**Catchment Management
Authority**
Hunter-Central Rivers

File: LVDA088

Your ref: MP 07_0171

**Subject: Exhibition of Environmental Assessment for QR National Train
Support Facility (MP 07_0171)**

Figure 7a: Vegetation Communities

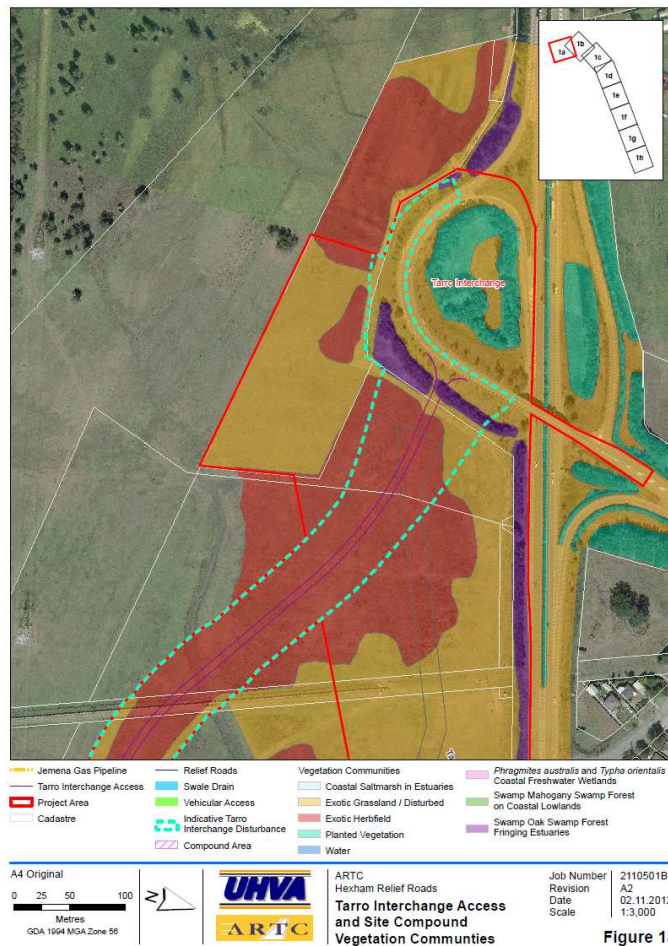
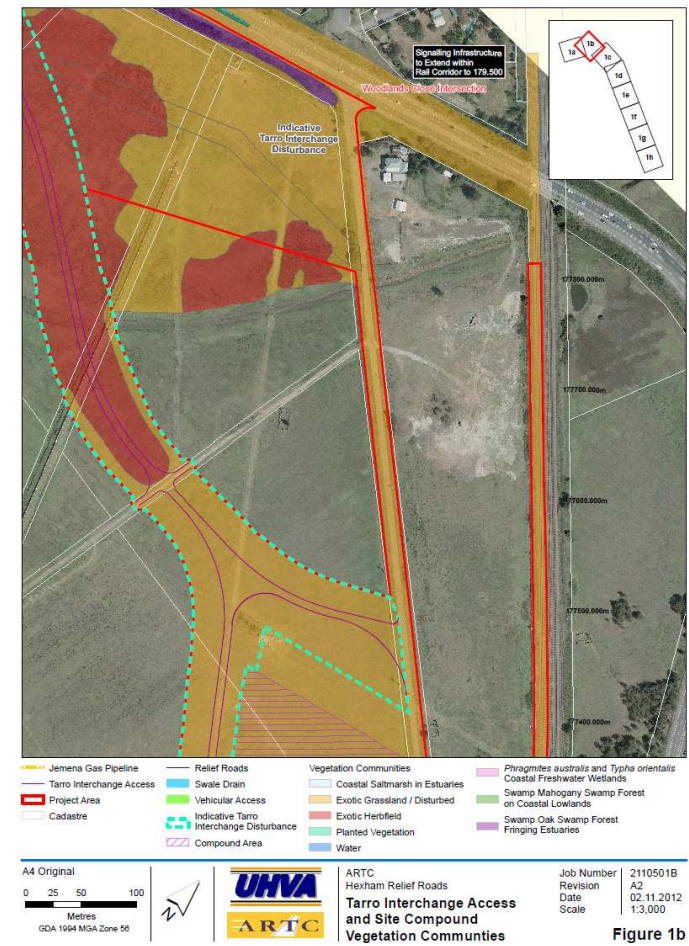
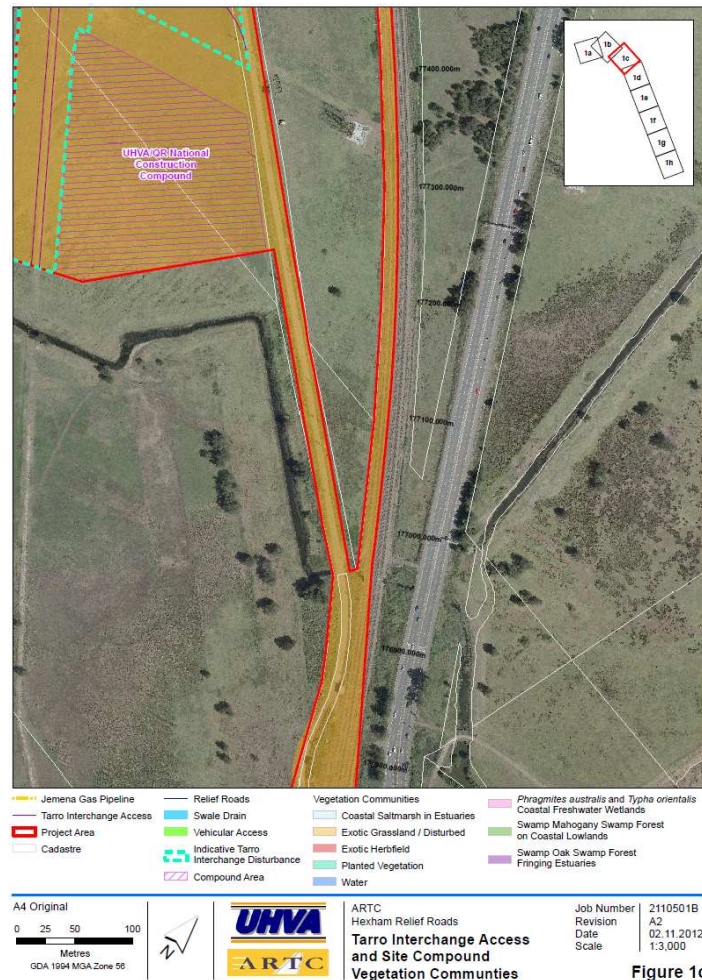
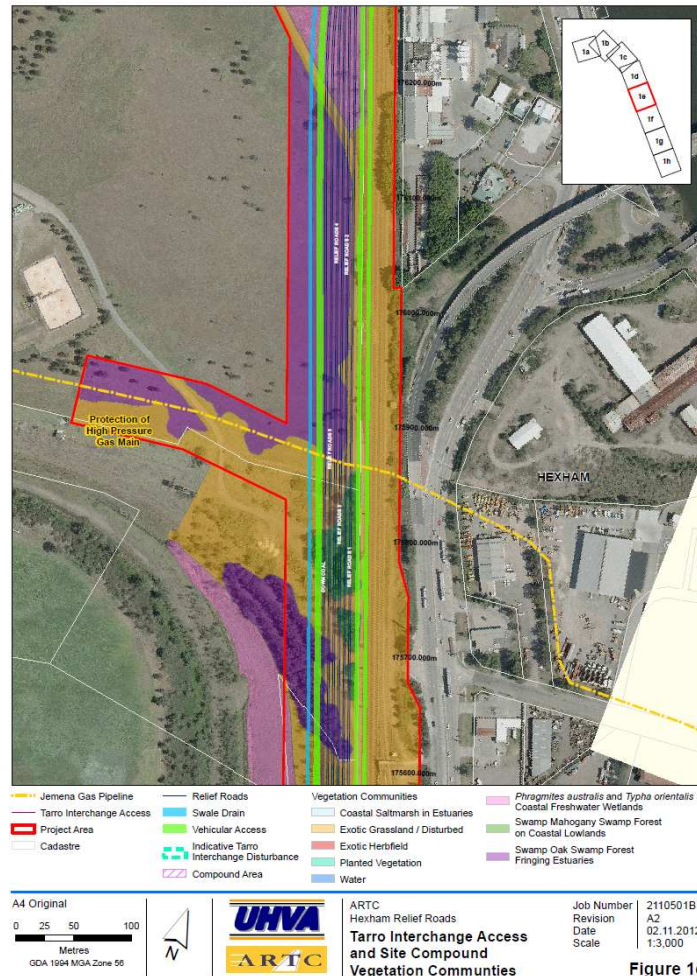
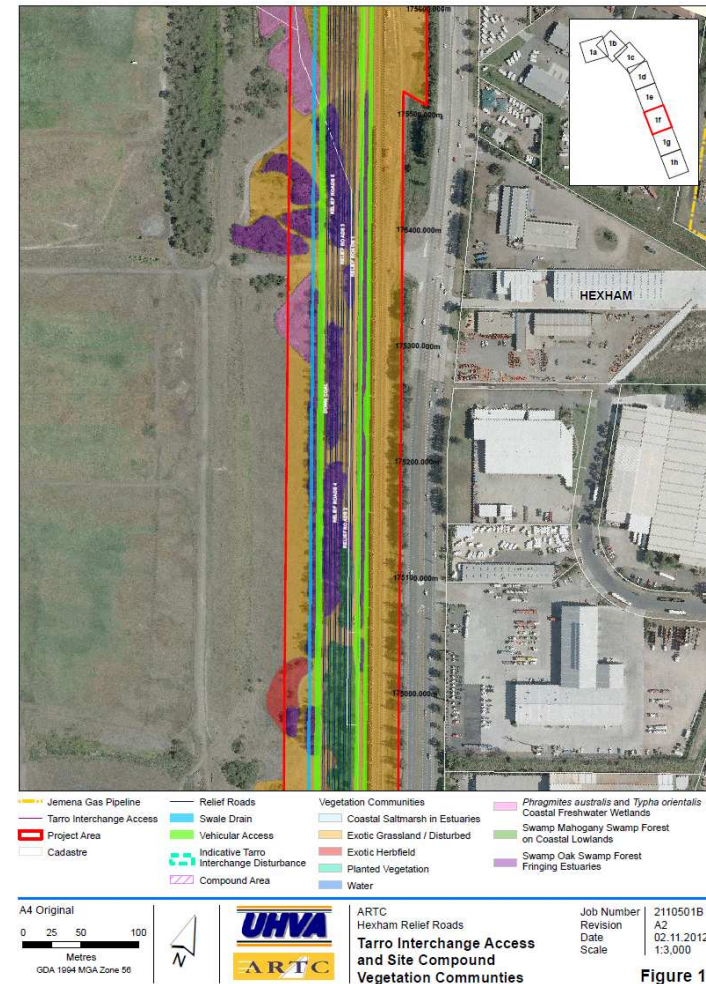
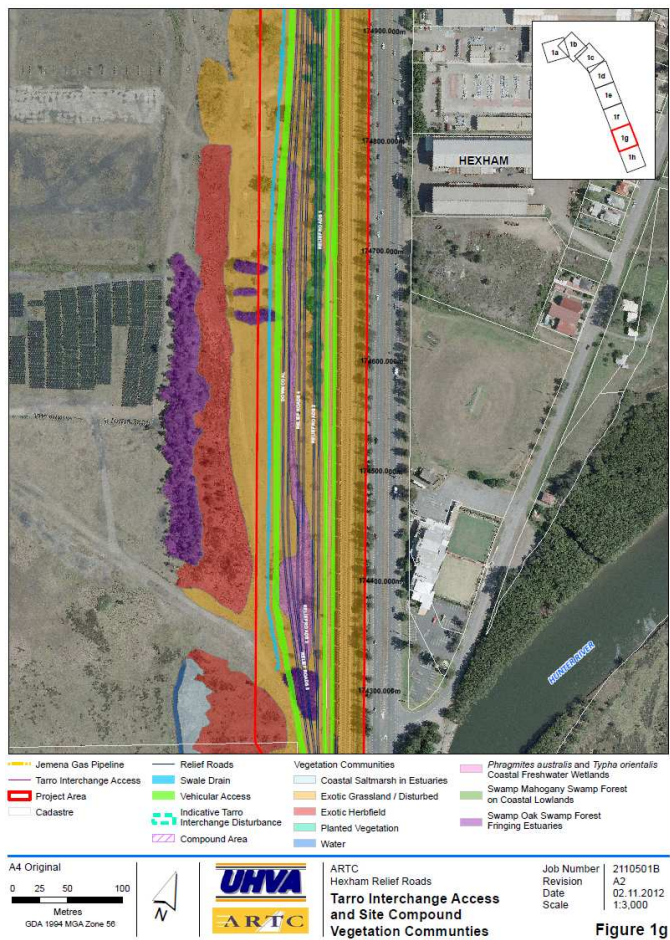
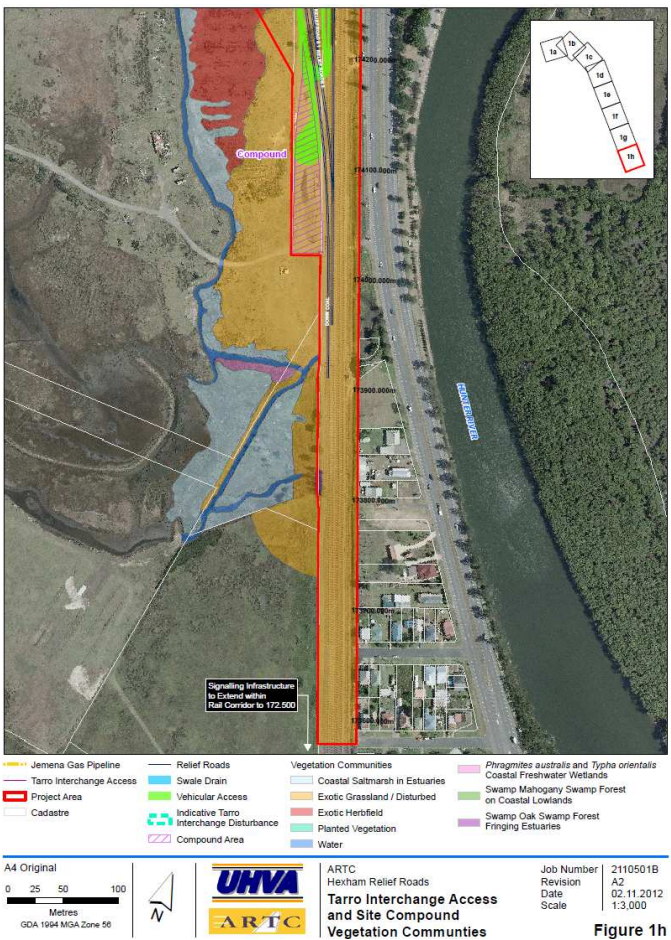
The EA states that 'the magnitude of this proposal has been assessed with the result that no threatened species or communities are considered likely to be significantly affected by the proposal'. The CMA notes that the building footprint for the Northern construction compound (3 ha) is located on predominantly cleared land whereas the southern construction compound (5 ha) will involve the clearing of EEC. The proposal will require the removal of 9.1 ha of EEC within the total 10.64 ha native vegetation removal and must be offset under the CMAs Catchment Action Plan (CAP).

In the first instance, the CMA suggests that moving the Southern construction compound to the west would reduce the impact on native vegetation and this should be considered.

The CMA is concerned however that a significant proportion of the offset in the southern portion of the proposal is identified as a 'Future Investigation Area' (Figure 7) and seeks clarification as to the implications of this on future offset areas.
